EP/34/11/NMA

Application for a non-material amendment following a grant of planning permission.

Two Storey rear extension with balconies, extension to left space forming dormer to front and rear, two storey front extension, single garage with integral cycle area and bin storage and raised patio to rear

EP/124/10

Side Elevation - East

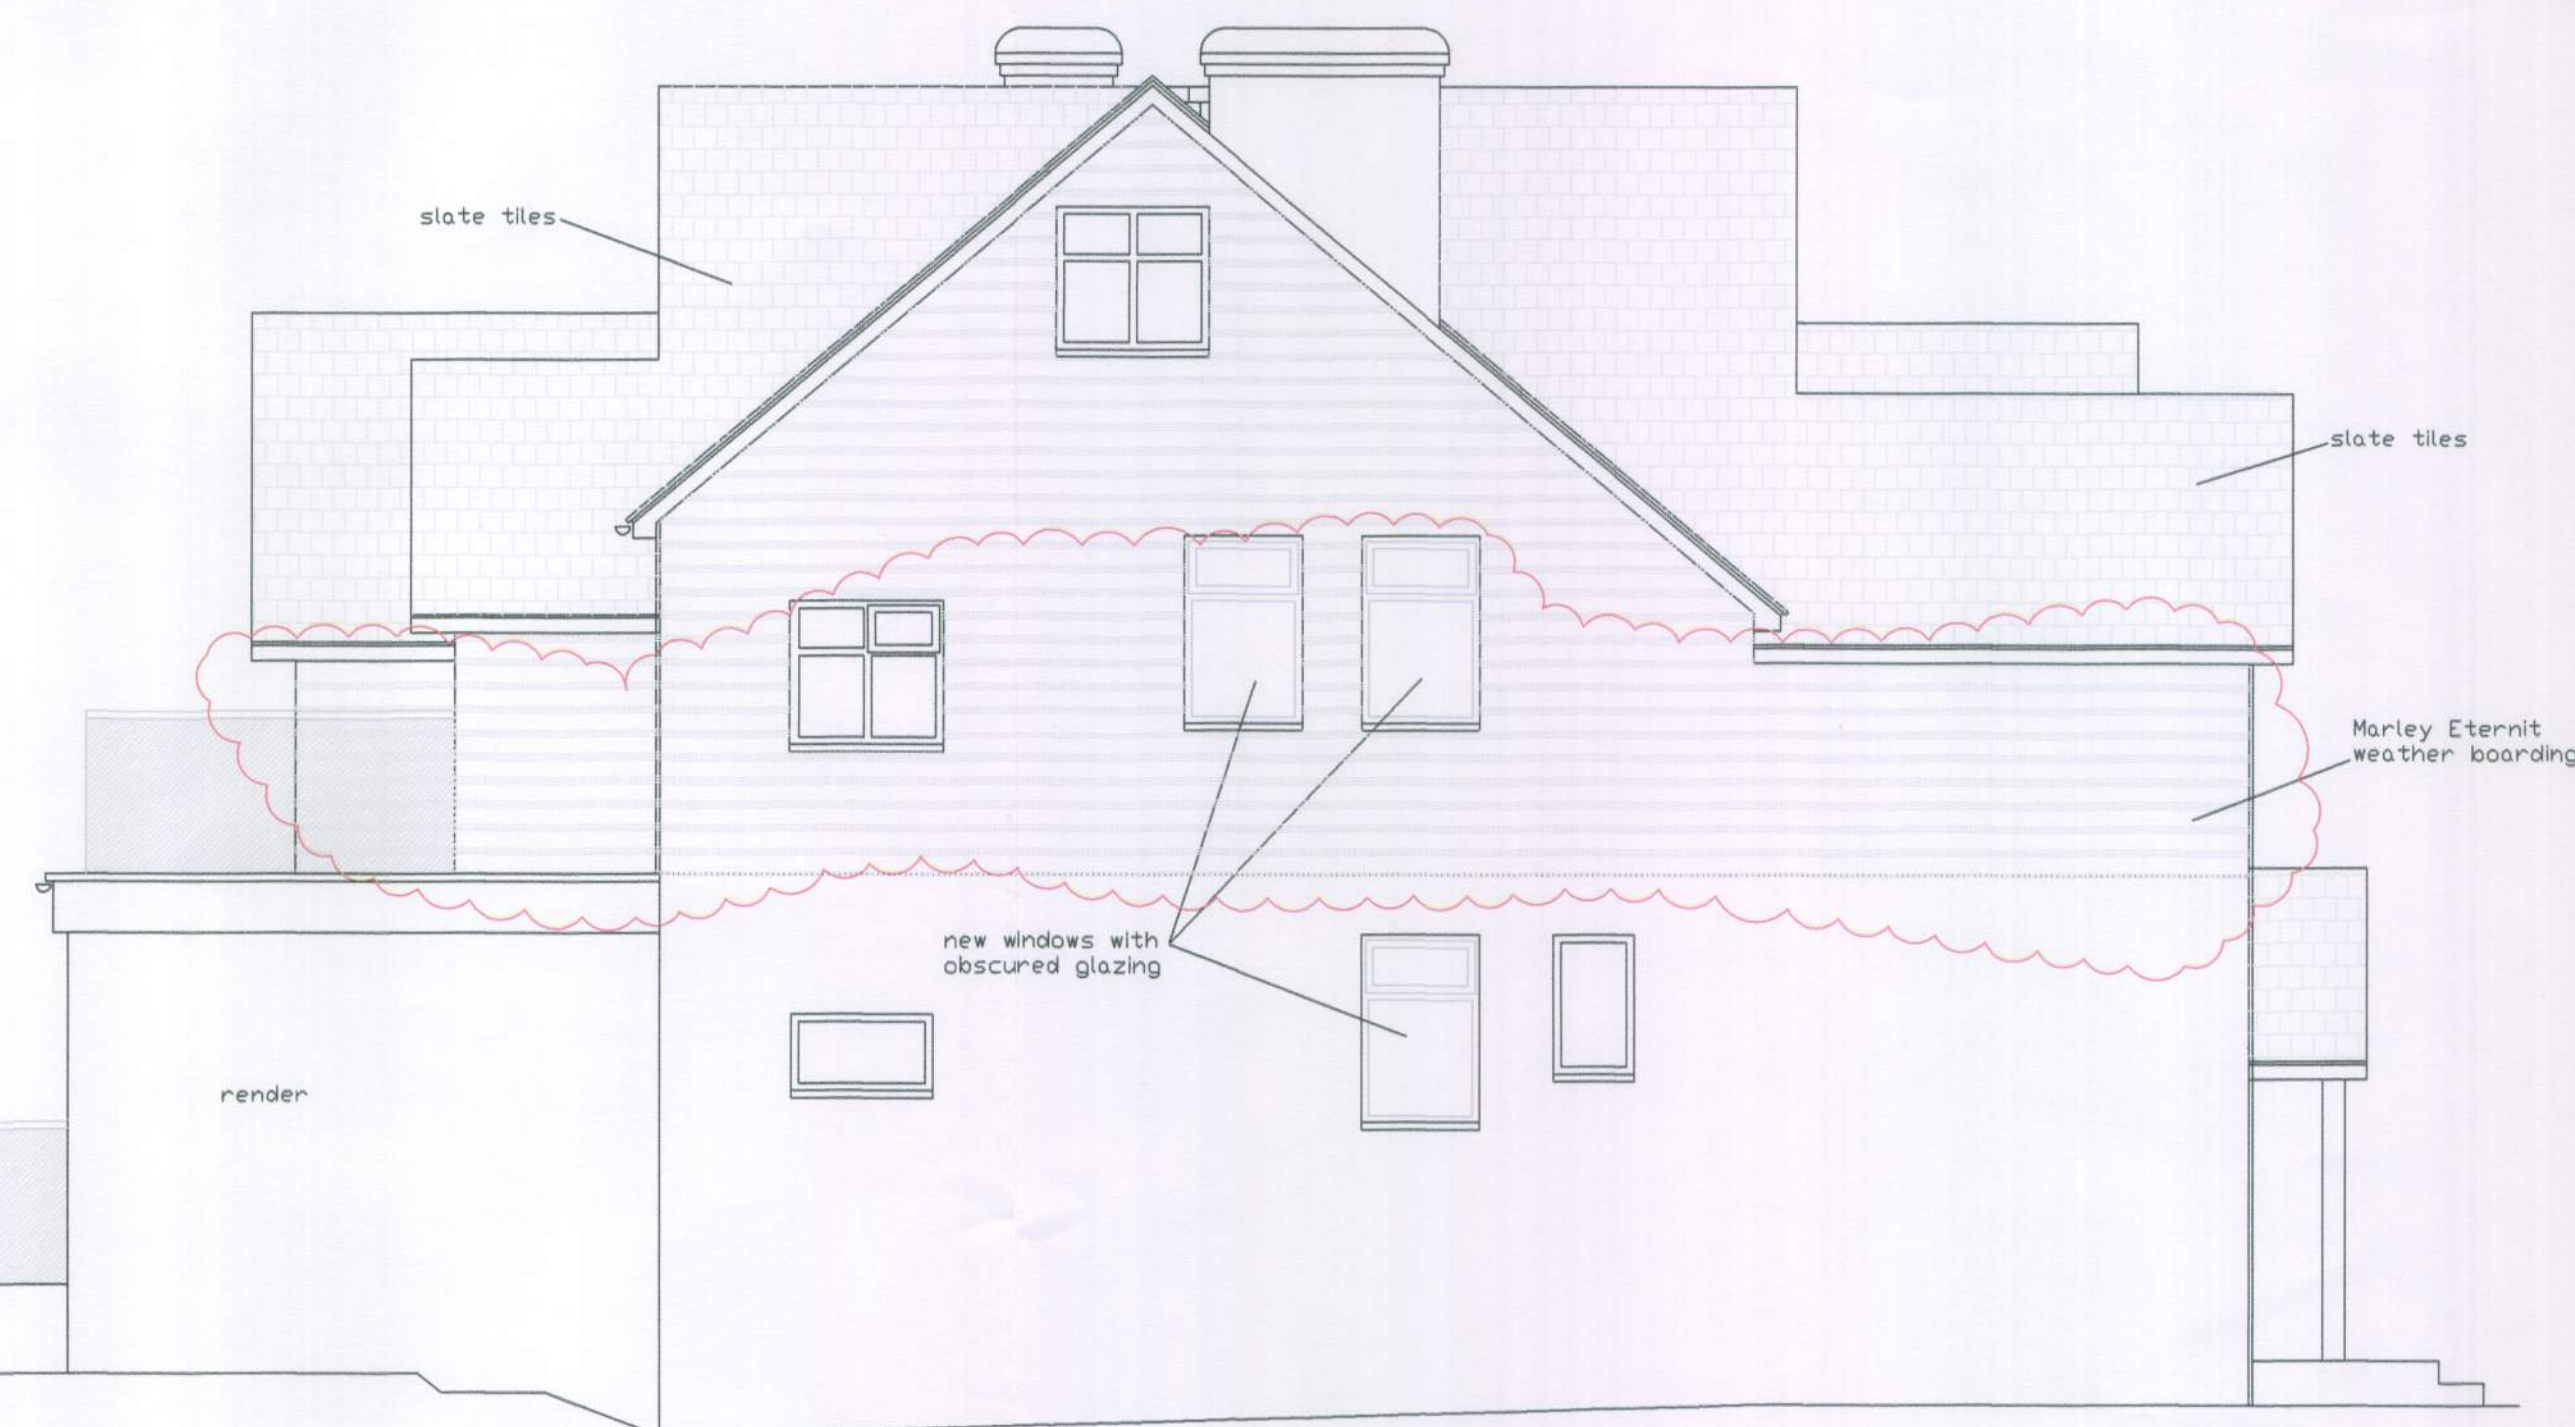
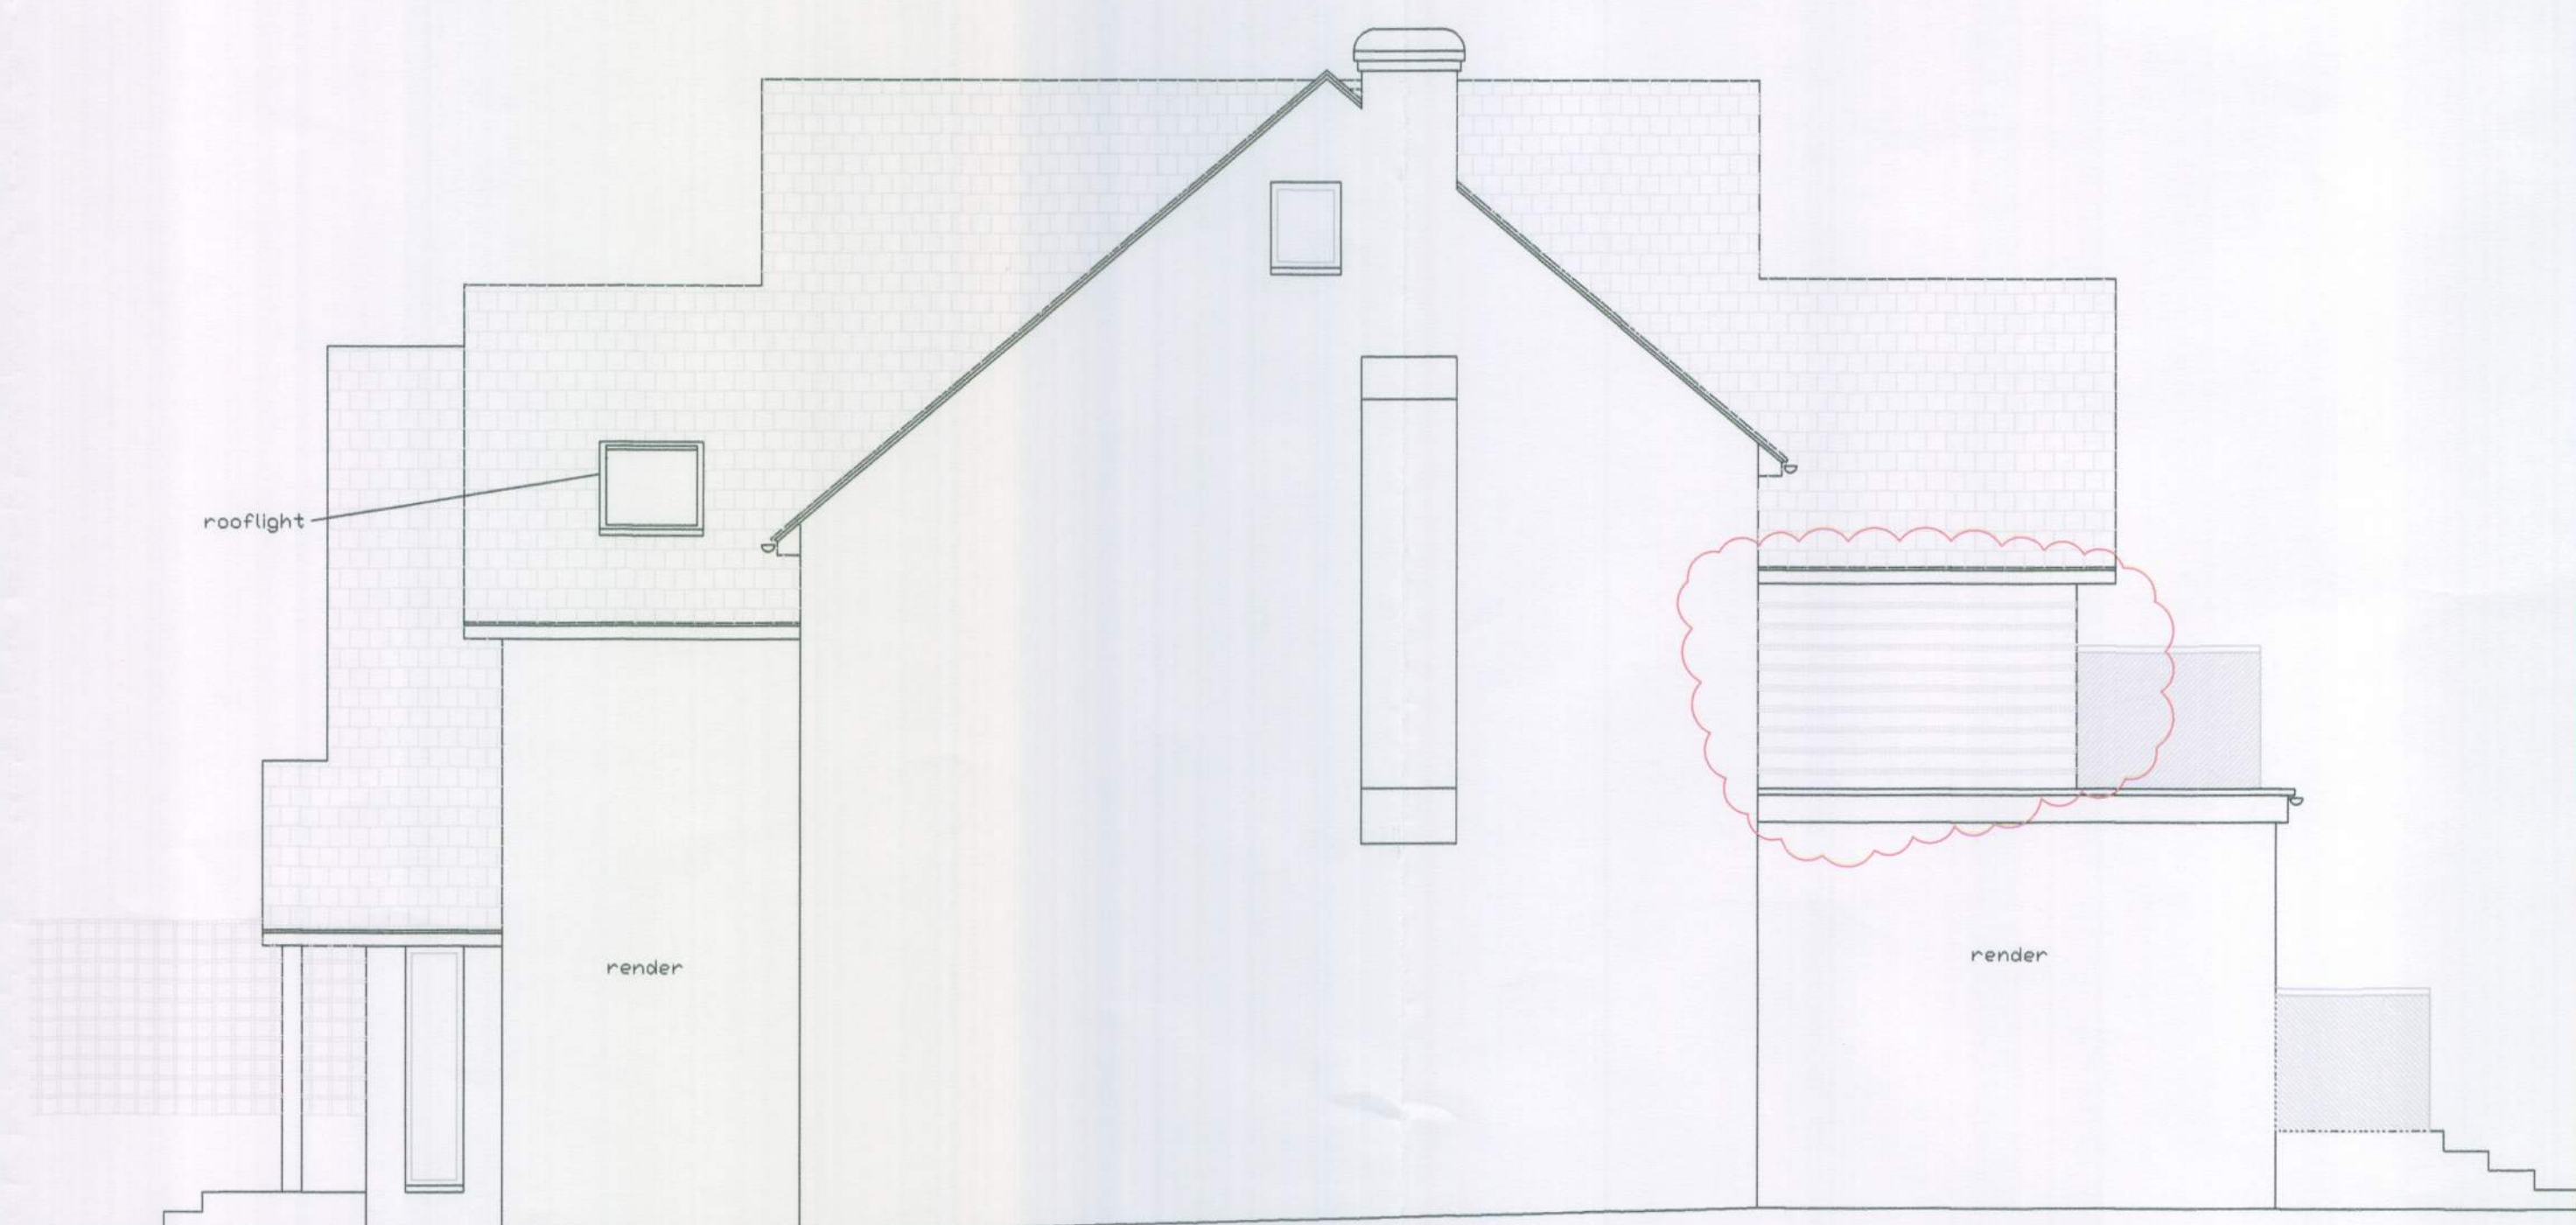
- Round 'Porthole' windows in North Elevation changed to 'diamond' shape
- Render to part of north elevation changed to weather boarding
- Render to part of south elevation changed to weather boarding
- Render to part of east-west elevations changed to weather boarding
